**GORTLOUGHRA WINDFARM,
AN TSEITHE BEAG (SHEHY BEG),
GORTLOUGHRA, CLOGHBOOLA AND
INCHINROE, CO. CORK**

RESPONSE REPORT FOR REQUEST FOR FURTHER INFORMATION (RFI)

August 2026

RESPONSE TO RFI FROM AN COMISIÚN PLEANÁLA

PLAN VIEW OF SETTLEMENT PONDS (WITH DISCHARGE TO DRAINS WHERE APPLICABLE)
SCALE: 1:50

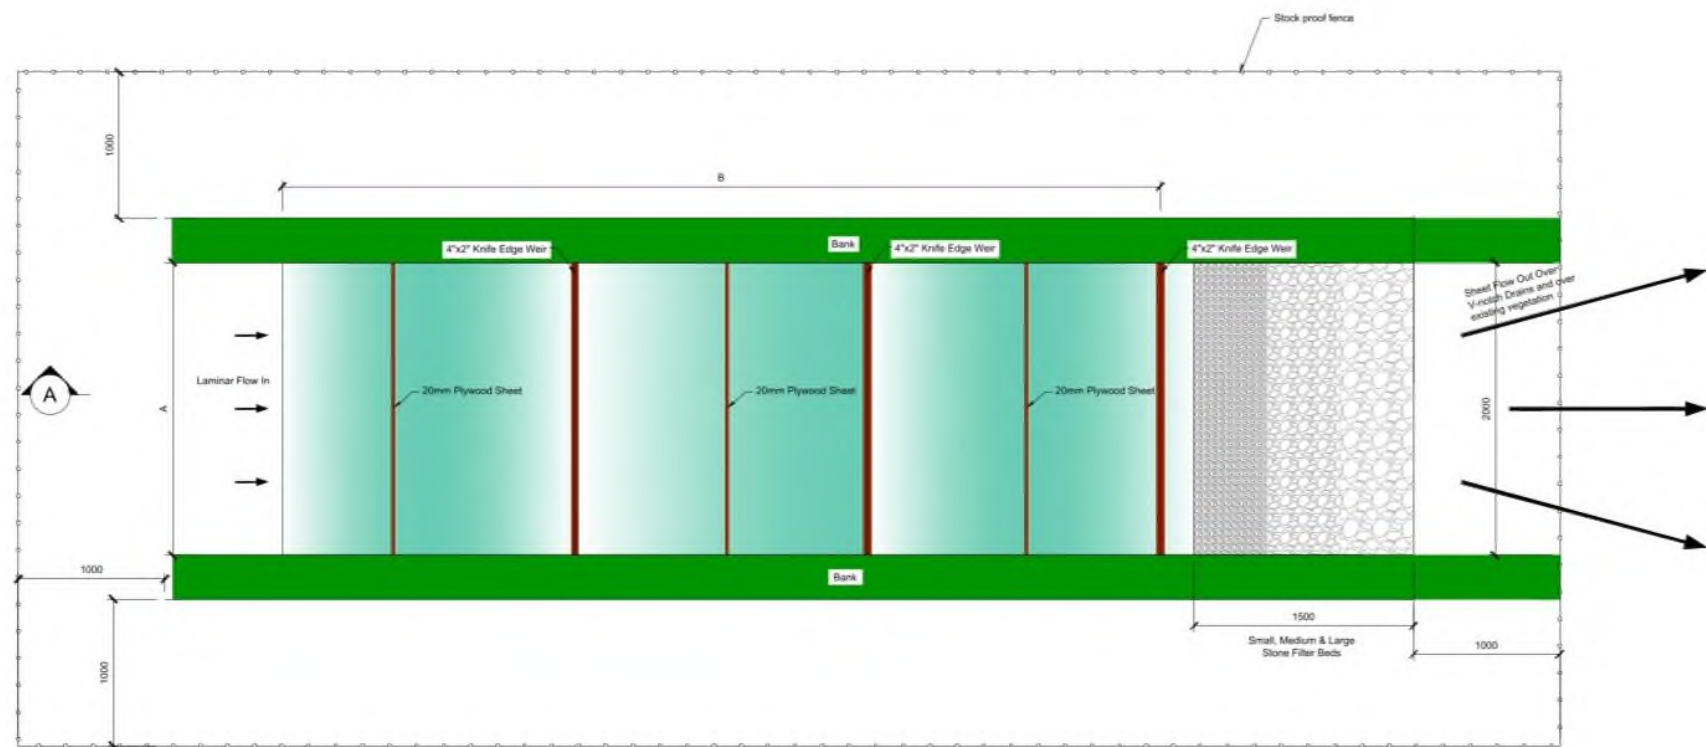
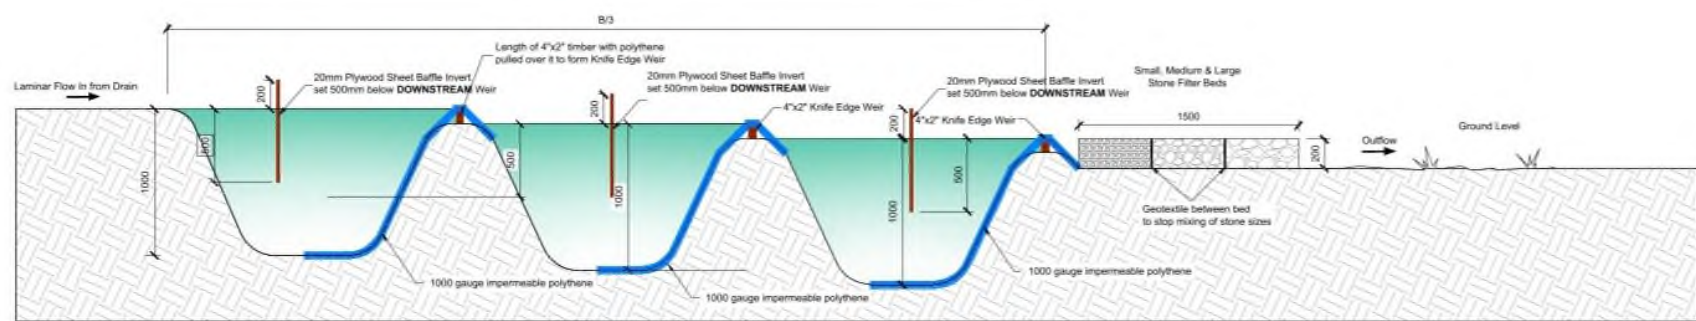
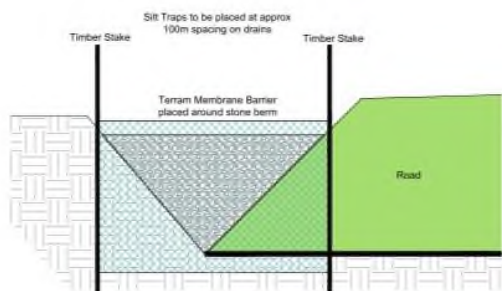
2. *As detailed in Section 5 of the submitted PSRA, it is stated that loading of the peat during or after construction will be avoided at all times, but particularly at the following locations where a Safety Ratio of below 1.0 was calculated with a traffic loading of 20kP:*

- *To the west and south of T01,*
 - *East of T02, and,*
 - *North of T08 (Figure 14).*

From a review of the submitted layout plans, it is proposed to provide settlement ponds (SP05 and SP17) at locations proximate to areas of the site that have been attributed a Safety Ratio of below 1.0 (traffic loading of 20kP). You are required to therefore demonstrate that the provision of these settlement ponds will not intensify the potential for slope instability at these locations. If deemed necessary, revised drainage proposals shall be submitted to mitigate any potential risk. Noting, the additional mitigation measures outlined within the PSRA, the updated PSRA shall have due regard to the finalised drainage proposals for the proposed development (see further point below under Hydrology & Hydrogeology). The updated PSRA shall also include the original Laboratory Test Results (Appendix 3) which do not appear to have been enclosed with the application.

2. To mitigate any possibility of the ponds being located in an area of localised instability (with a designated Safety Ratio of below 1.0), the two ponds have been moved further from the higher risk areas. SW05 has been moved approximately 55m north and SP17 has been moved approximately 55m west as shown on revised drawings Drawing No. No. 6460-JOD-GLWF-XX-DR-C-0202 and No. 6460-JOD-GLWF-XX-DR-C-0208 included in **Appendix 3**.
